MONUMENT GLAMPING SITE PLAN
16315 RICKENBACKER AVE.
MONUMENT, CO 80132

SITE PLAN

SITE PLAN

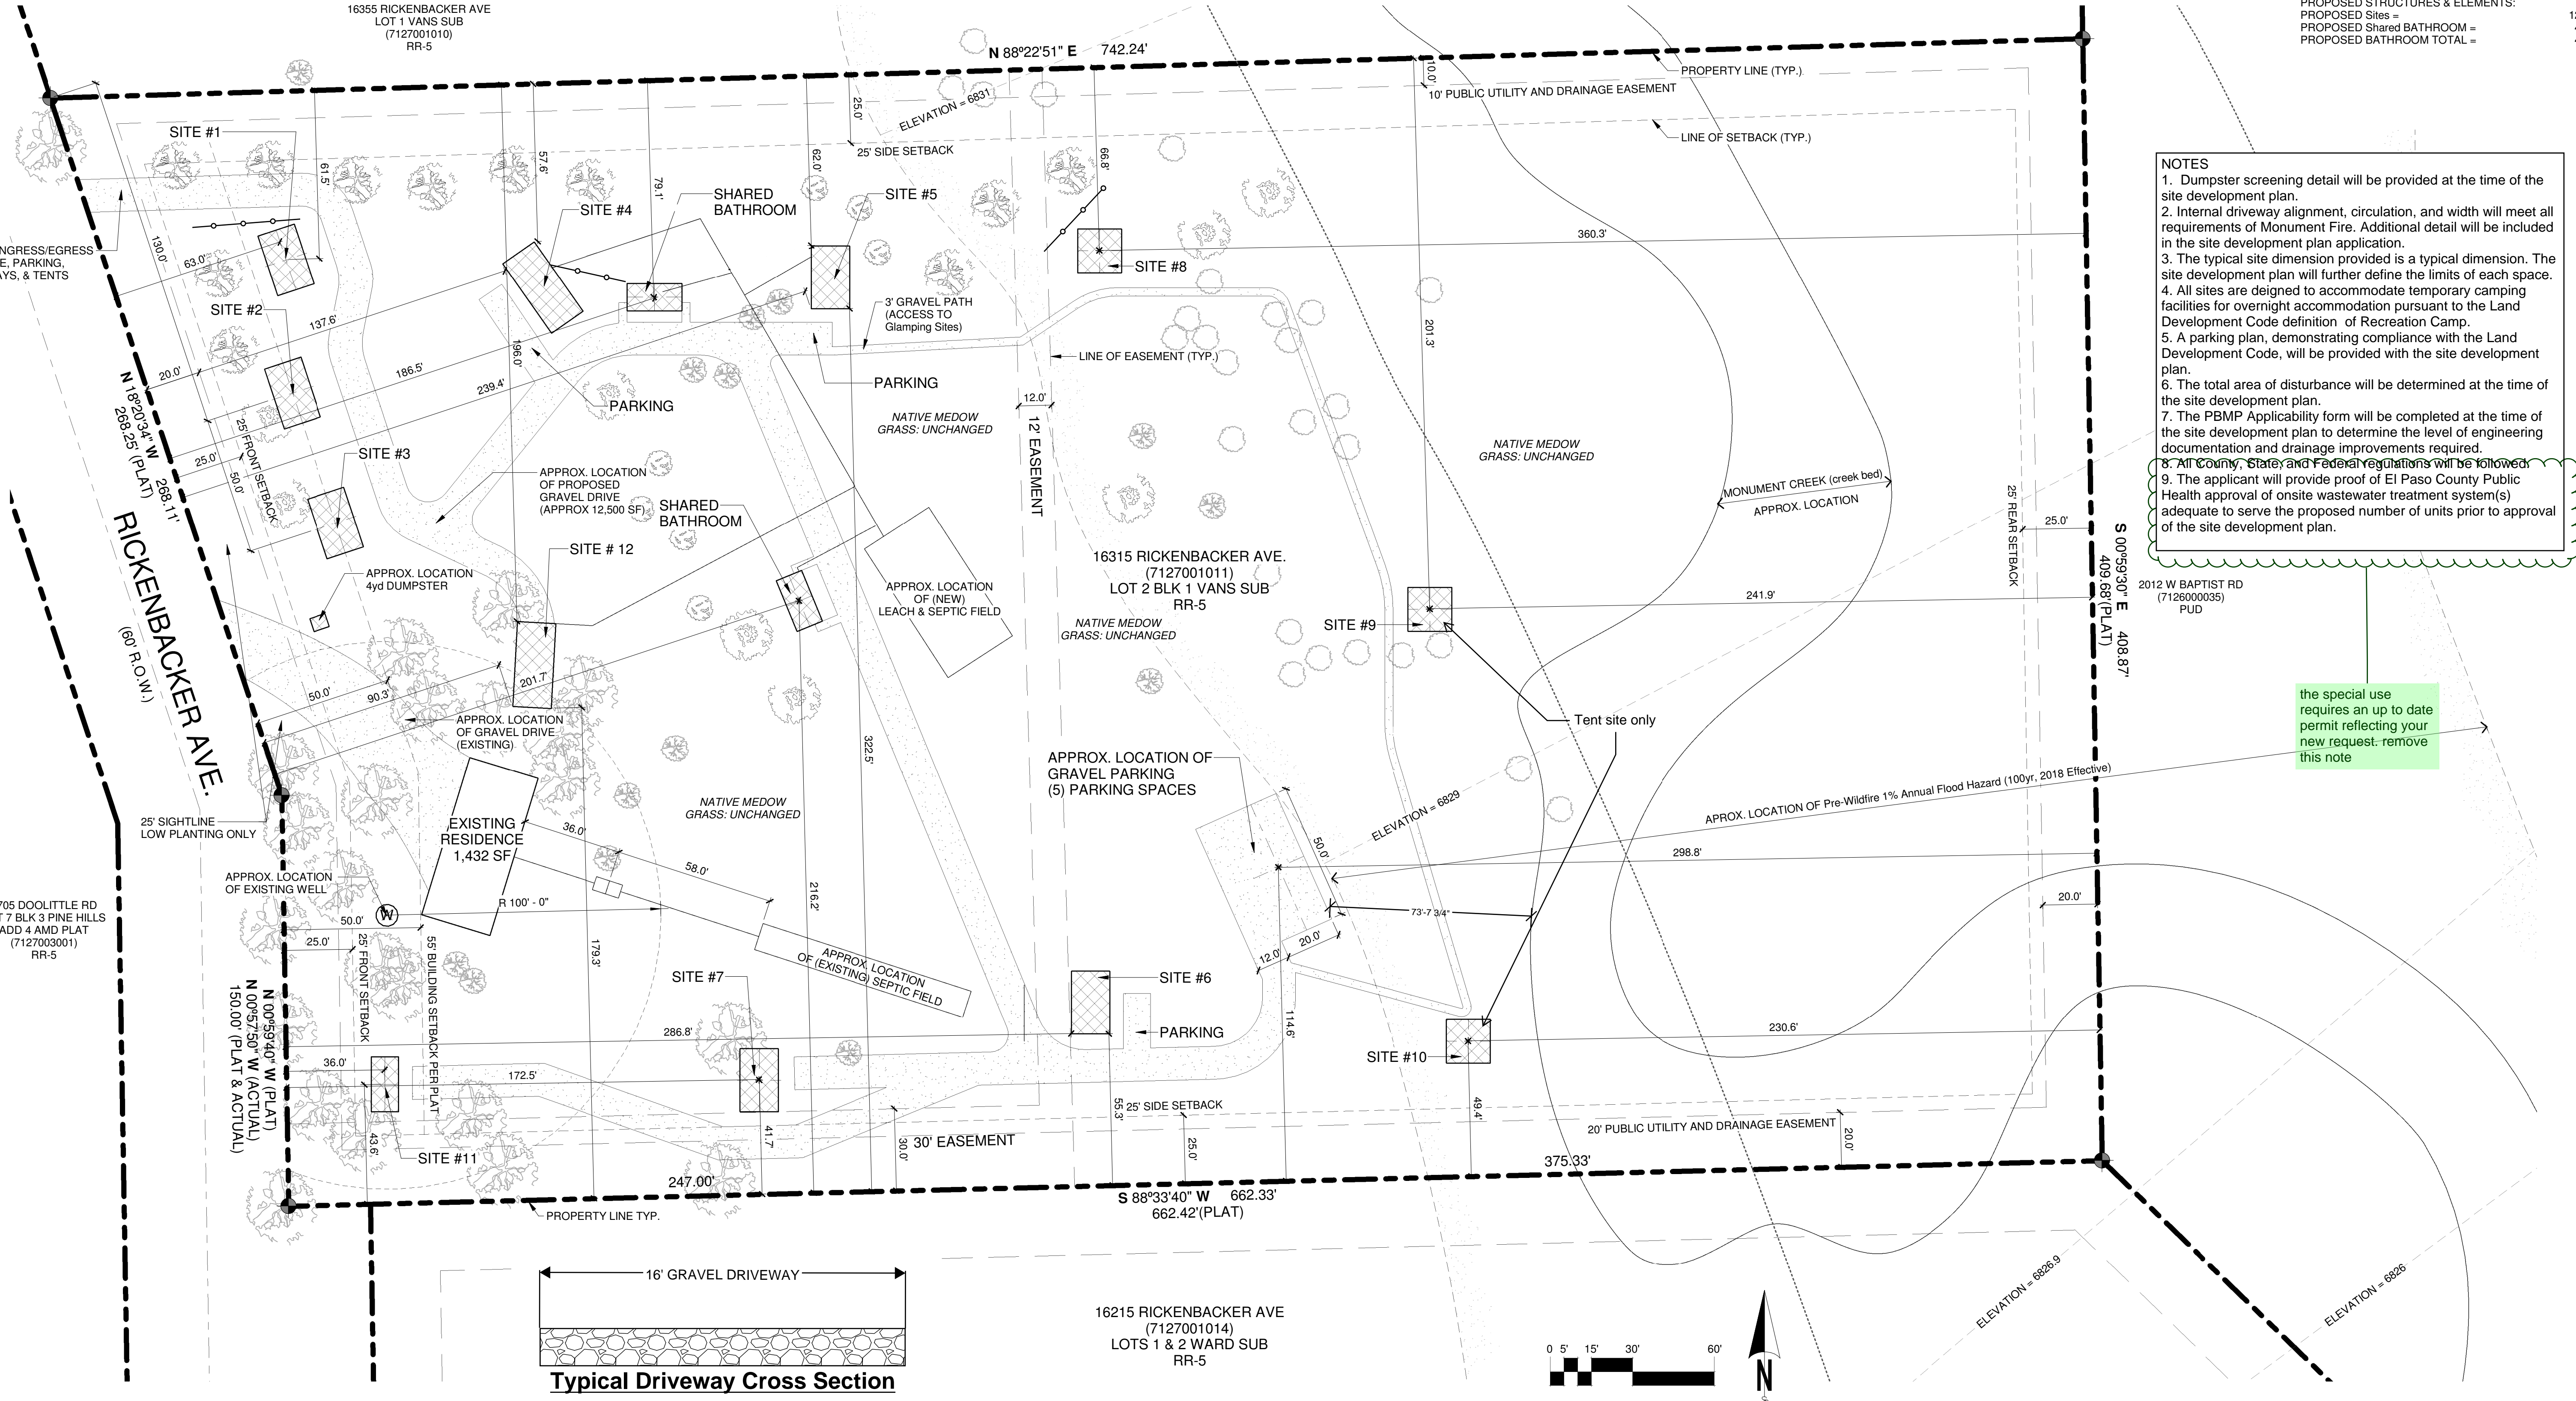
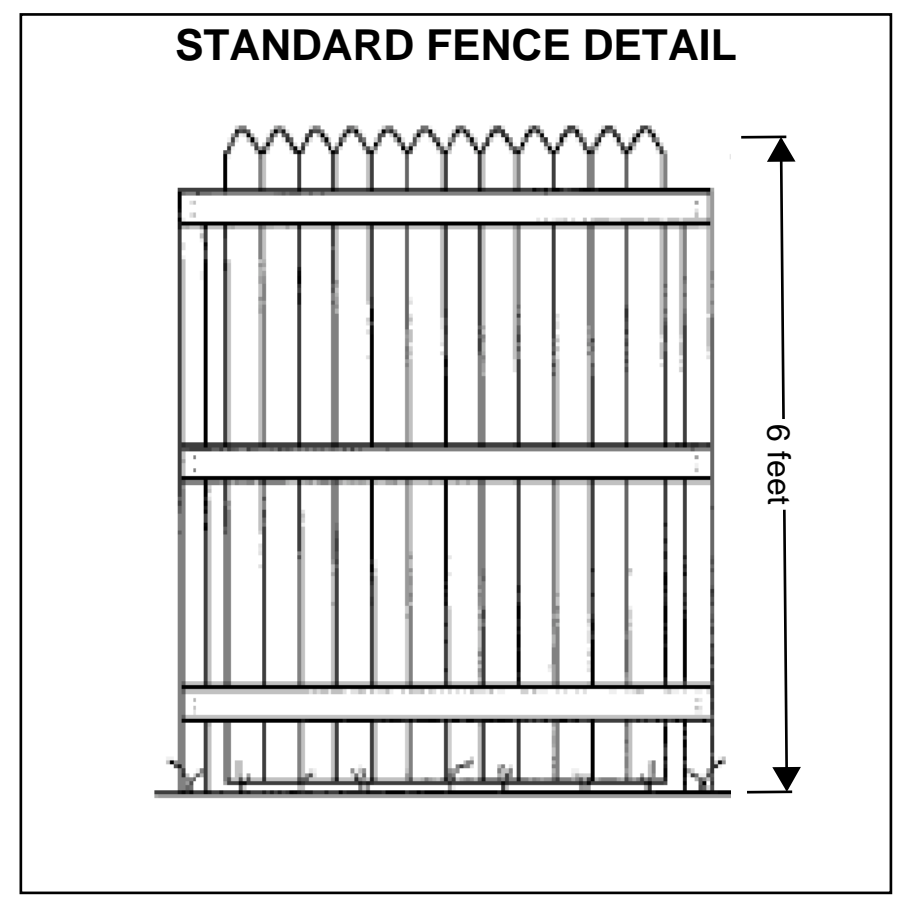
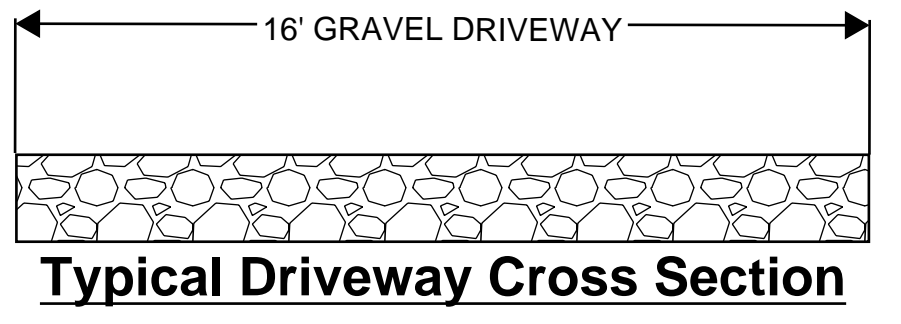
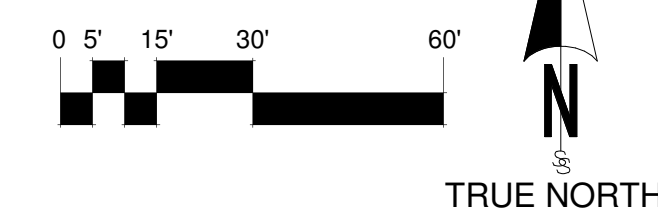
Please include:
 -what type of structure each site is
 -what is the sq footage of each site
 -where is the RV that has been on the previous reviews?

Please submit a secondary driveway access permit for the new driveway. Instructions will be provided in the EDARP review comment.

1432 + 480 + 3134 + 210 = 5,256
Please Revise

These numbers are the same as previous submittal and the proposal is asking for 4 more sites being added which means these numbers should change

Please Revise

Per the parking table, 1 spot per room, please update parking

Provide adequate radius turn around point
 One way access road min of 16ft in width per LDC 6.3.3, with two way 24ft. If the access roads dont meet width requirements a waiver may be required.
 Address internal access roadway width and circulation as its not clear where the turnaround points are located

Please depict the type of structure

Please provide measurements of parking lot to creek

Please depict the type of structure

RESPONSE: The type of structure will not be included, as the nature of a recreation camp is that the structures are temporary. A note has been added to reflect this.

A typical site dimension has been added along with a note identifying that the limits of the space will be further defined with the site development plan.

RESPONSE: the secondary driveway permit will be submitted at the time of the site developed plan application.

RESPONSE: revised per "typical"

RESPONSE: revised

RESPONSE: note added to indicate this detail will be provided with the site development plan.

RESPONSE: Additional discussion and meeting with Fire has occurred. A typical width has been provided. A note has been added to indicate that more detail will be provided at the time of the site development plan and that all fire requirements will be satisfied.

RESPONSE: this detail will not be provided per the definition of a recreation camp.

RESPONSE: this detail will not be provided per the definition of a recreation camp.

RESPONSE: revised

RESPONSE: this detail will not be provided per the definition of a recreation camp.
